Our Case Number: ABP-309770-21

**Re: Proposed development of up to 15 wind turbines with a tip height of up to 175 metres and laying of approximately 26km of underground electricity cabling to facilitate the connection to the national grid, and all associated site development works
Townlands of Camagh, Carlanstown, Coole, Clonrobert, Clonsura, Doon, Monktown, Mullagh, Newcastle and other townlands, Co. Westmeath**

Please find attached an Observation on Further Information on case Nos 309770-21 Coole Wind Farm SID.

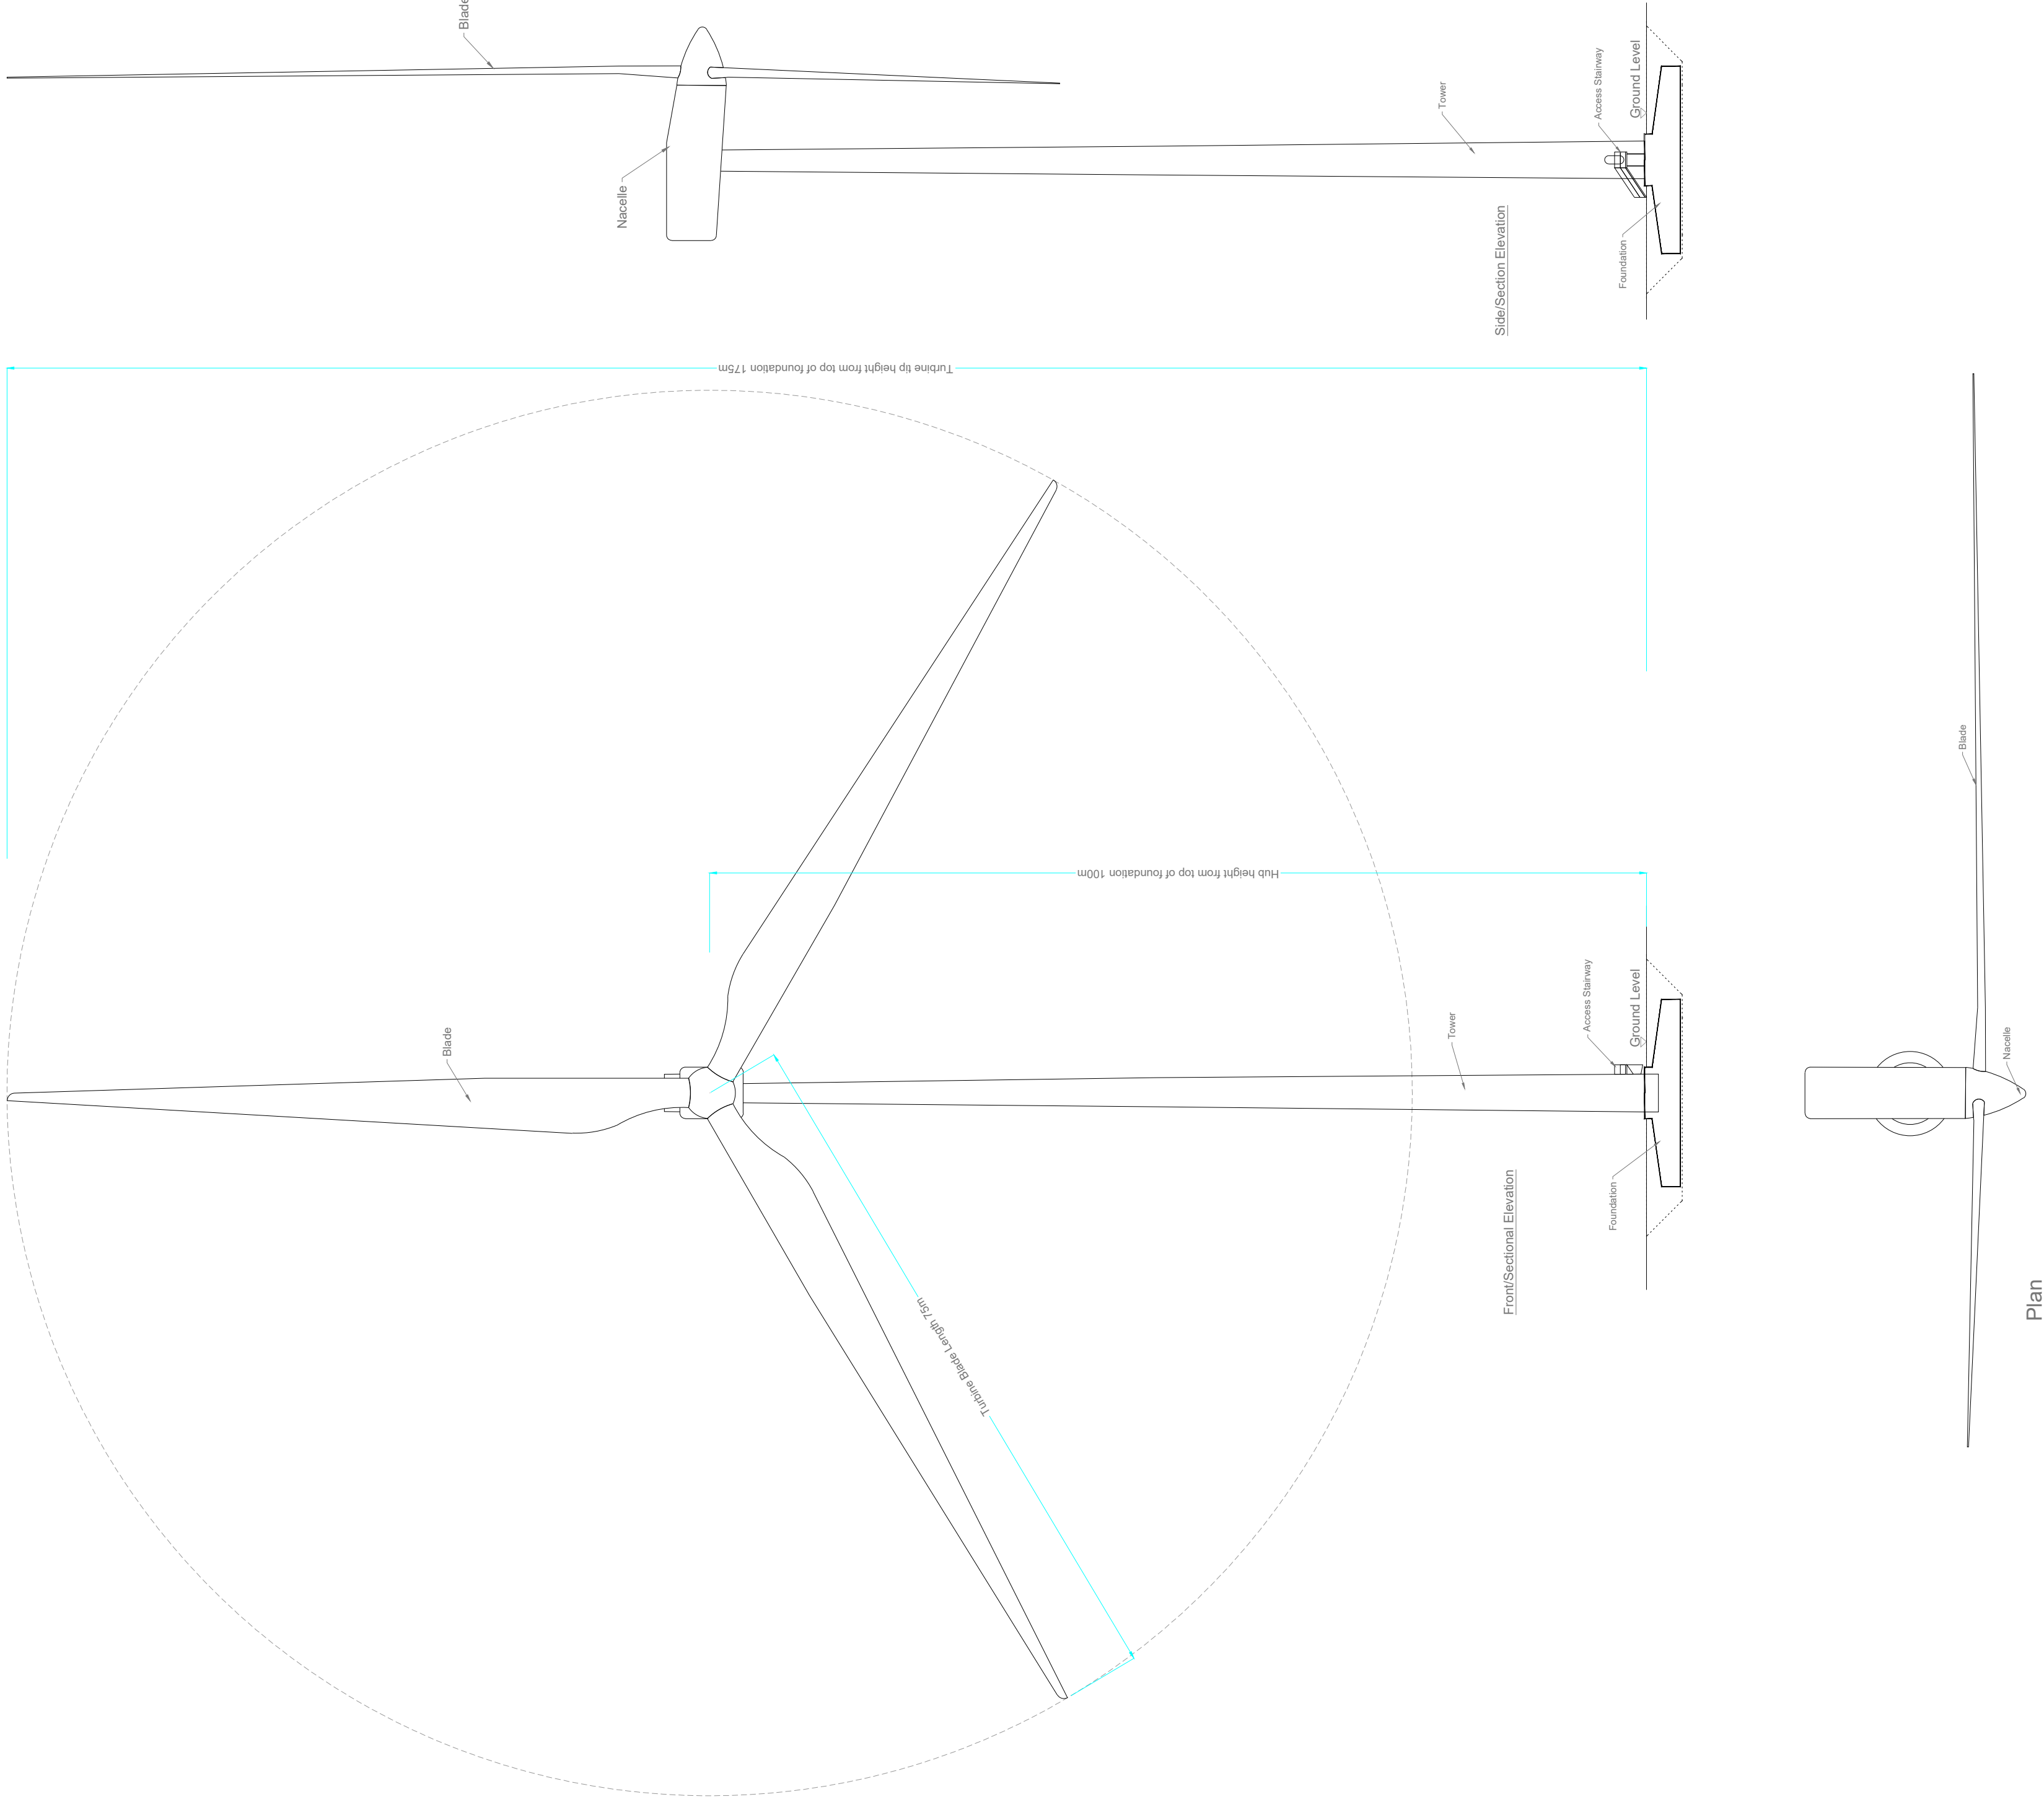
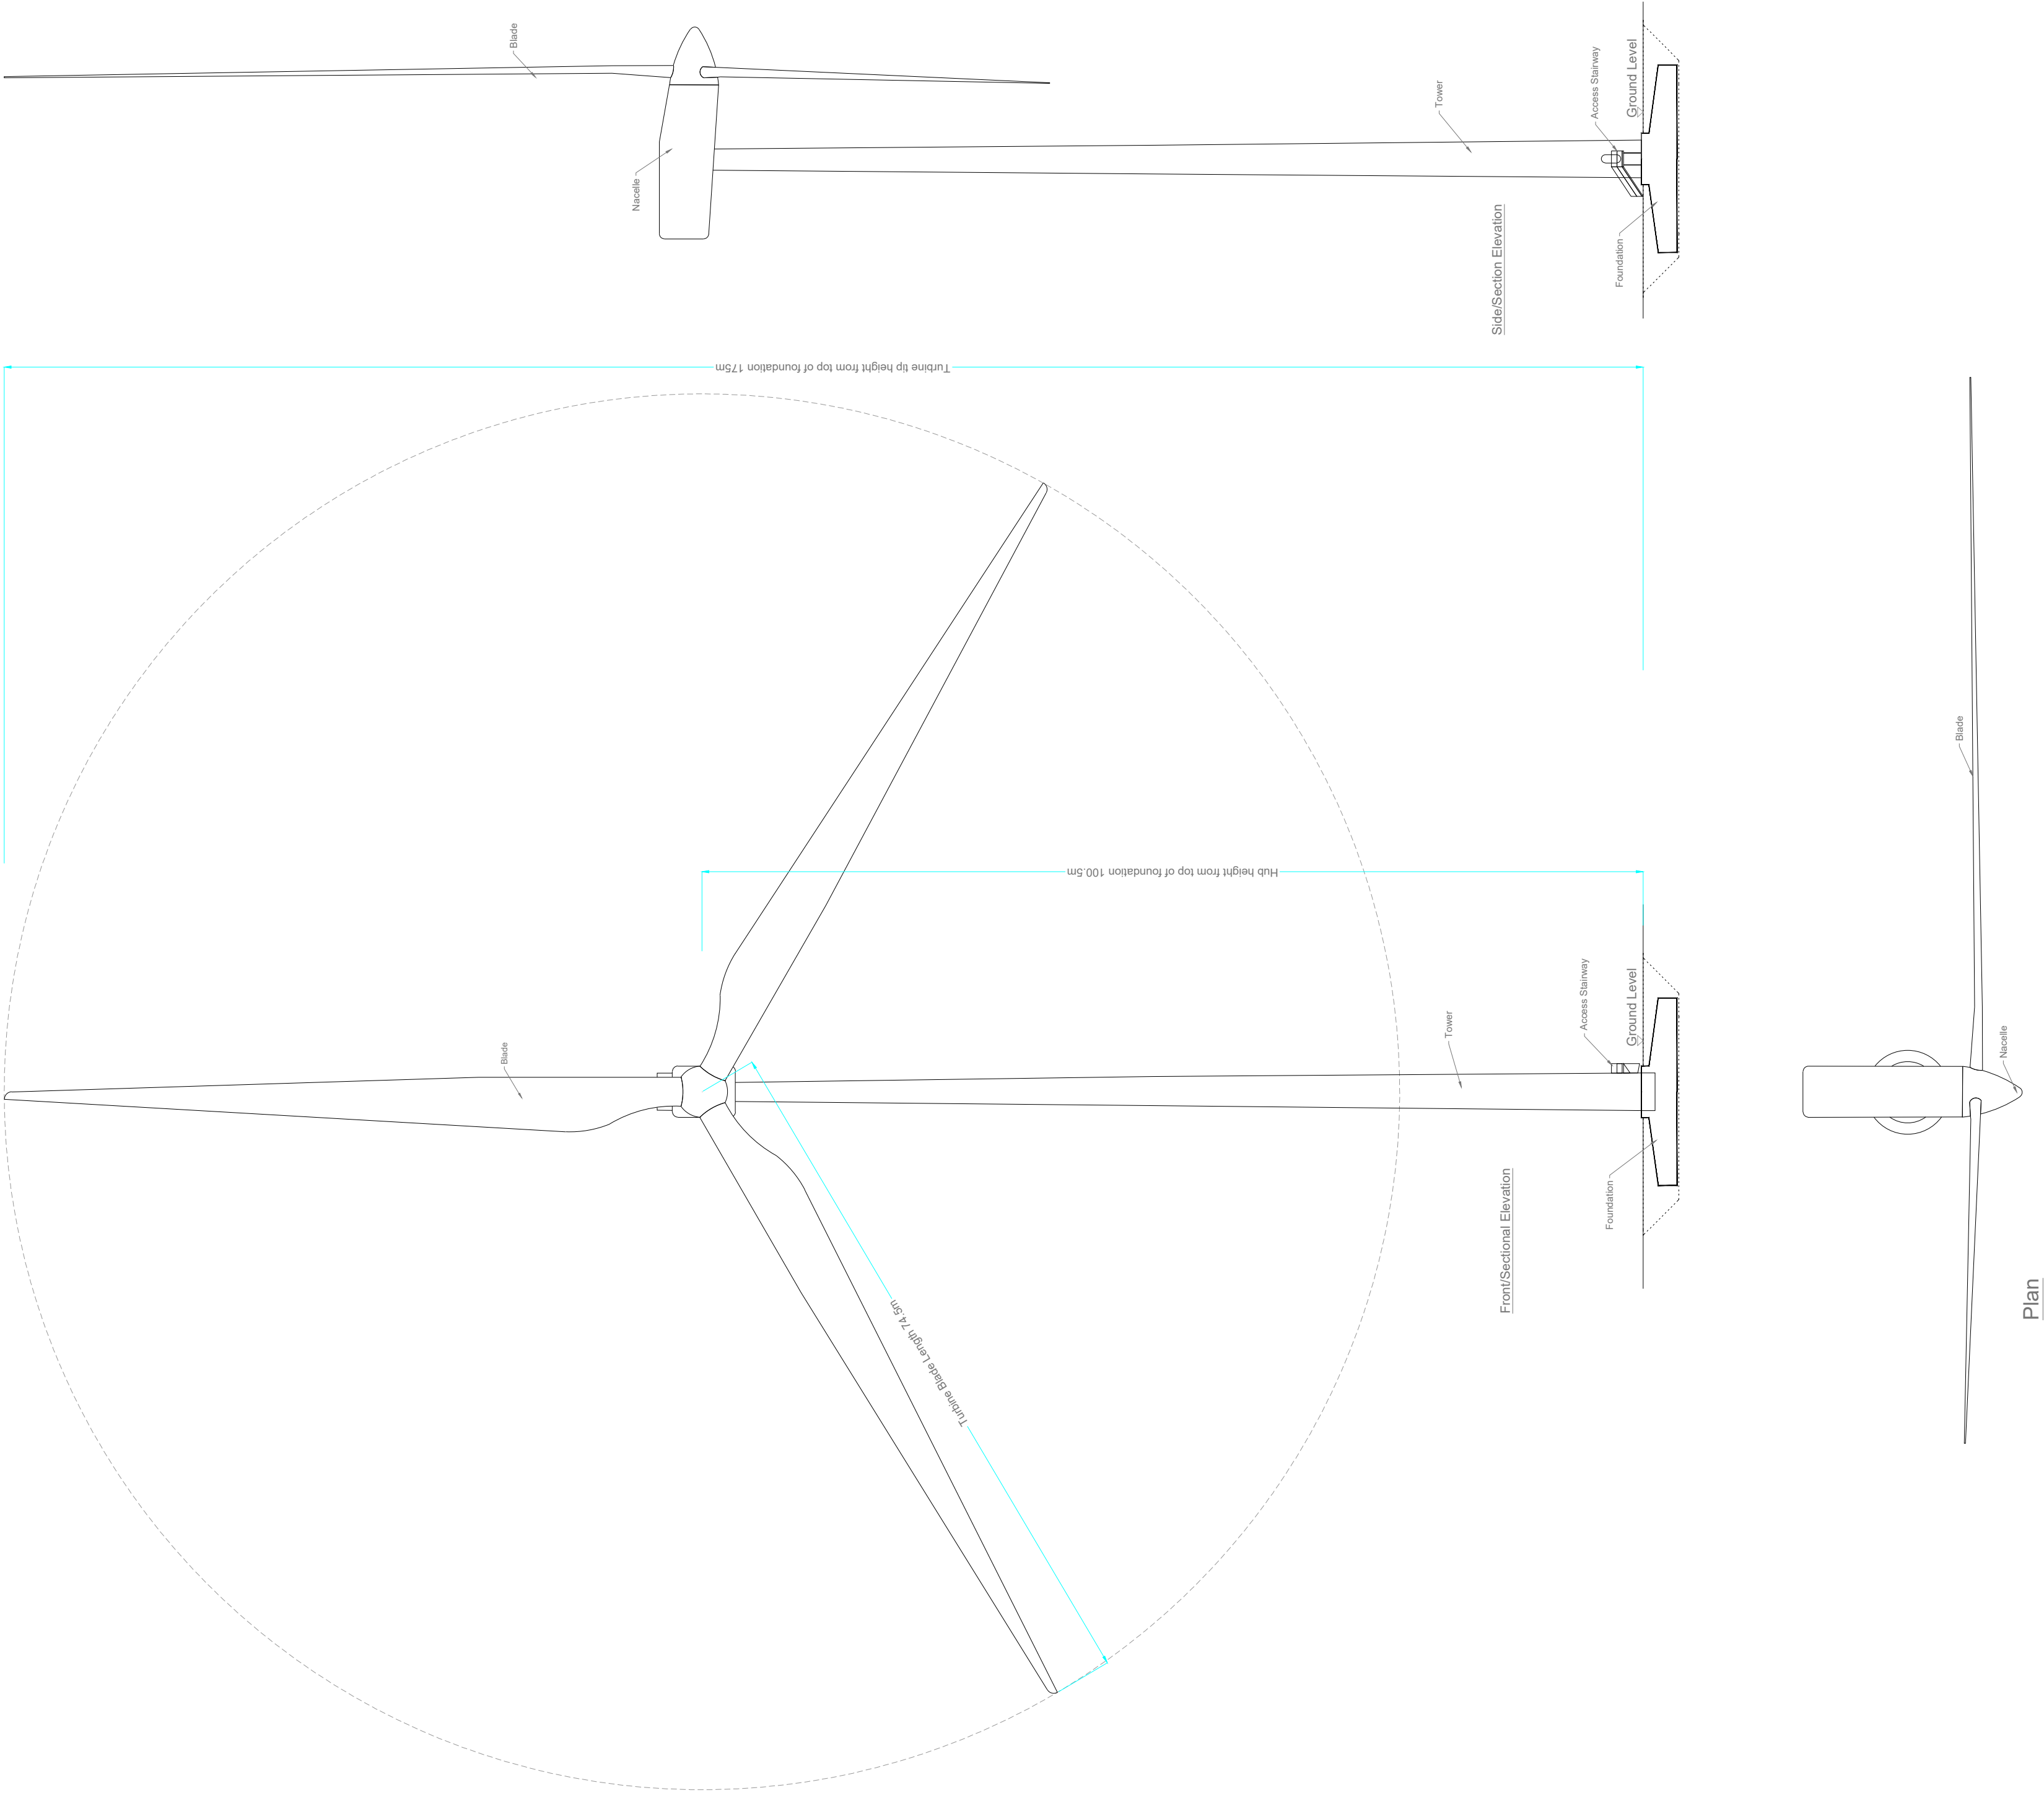
- 4. There is nothing “reasonably limited” about the range as claimed above. The facts are there is a 6m difference in rotor diameter which is over 20 feet. This is a significant increase in the size of the turbine so how is it that planning permission can be permitted for three different turbine configurations with this much of a width variation?**
- 5. Why would such latitude be given to an industrial wind farm development and how does this compare to revised planning applications with similar size increase for structures such as houses etc?**

- 6. The above point begs the question would such a range difference be allowed in a residential or commercial building in either an urban or rural settings and if not why should they be deemed acceptable for a windfarm**
-

- 7. In the above statement, it should be again highlighted that the CWF SID seems to be claiming a 20-foot difference in rotor diameter is not significant or that the scale of these giant industrial turbines is already so massive that an additional 20-foot difference would matter little in terms of its impact on the environment. Can they confirm if this is the case?**
- 8. Will CWF state more precisely, and in clearer language, that our interpretation of what they are claiming is either correct or incorrect what exactly do they mean?**
